From: Anna Harper [REDACTED]
Sent: 02 October 2019 15:44
To: Simon Davis <Simon.Davis@arun.gov.uk>
Subject: FW: [EXTERNAL] Fwd: Site 6, Chichester Road, Bersted

From: stephen jupp [REDACTED]
Sent: 26 September 2019 16:15
To: Simon Davis <Simon.Davis@arun.gov.uk>
Cc: Anna Harper [REDACTED]
Subject: [EXTERNAL] Fwd: Site 6, Chichester Road, Bersted

Status
for planning
Scale
1:200@A1
Job number
1526
Drawn
AR
Drawing number
L90-201
Date
Aug 2019
Revision
A

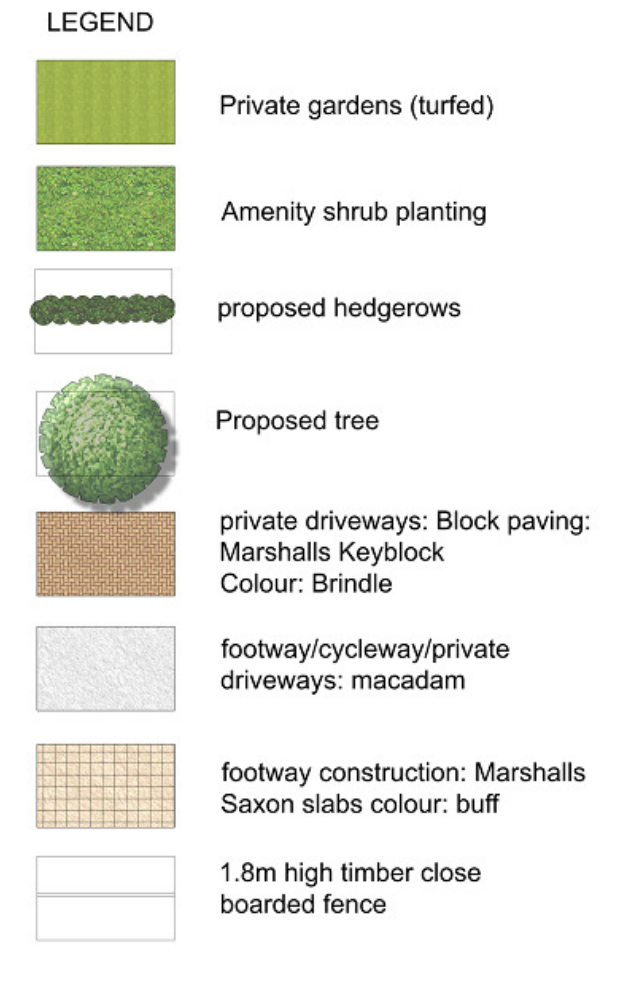
have amended plans been submitted yet to show the correct width of the landscape hedge and also that it is NOT to be included within the curtilage of any property but is fenced off separately and remains the responsibility of the management company to maintain as currently occurs along with the rear hedge

In addition the submitted drainage plan appears to show the removal of the corner of the landscape where the side and rear parts meet - this is unacceptable. i do not see why it needs 4 spaces and if 3 are required one could be adjacent to the garage.

This plot should also be moved 1.5m to the west to provide a 1.5m gap between its side wall and the hedge. Experience shows that the hedge will be removed in part to get the scaffold in otherwise. There is room to move it to the west

drawing L90-201 Rev A seems to remain current but the drainage plan contradicts this plan

Mr Jupp has queried whether amended plans have been submitted yet to show the correct width of the landscape hedge. As discussed, I am content that the plan issued to you on Monday 16th September (Tree Plan JN283-2500) along with the updated landscape plan issued on 19th August 2019 address the matter of the existing hedge and that you have adequate information to determine on that basis.

It would be extremely impracticable for the hedge not to be included within the curtilage of any property. Not only would this cause future management issues, it would also create a potential rat run and unattractive frontage to Chichester Road. It is perfectly natural for a hedge to form the boundary to a curtilage, as it does to the property adjoining the site, so this is something we are not willing to look at implementing.

Lastly, Mr Jupp has quite rightly highlighted discrepancies between the proposed site layout and drainage strategy plan submitted. Can I suggest a drainage condition be imposed on this permission, given that we have not yet progressed to full detailed technical design this drawing has not yet been produced. If you feel it is required ahead of approval, I will of course instruct the work.
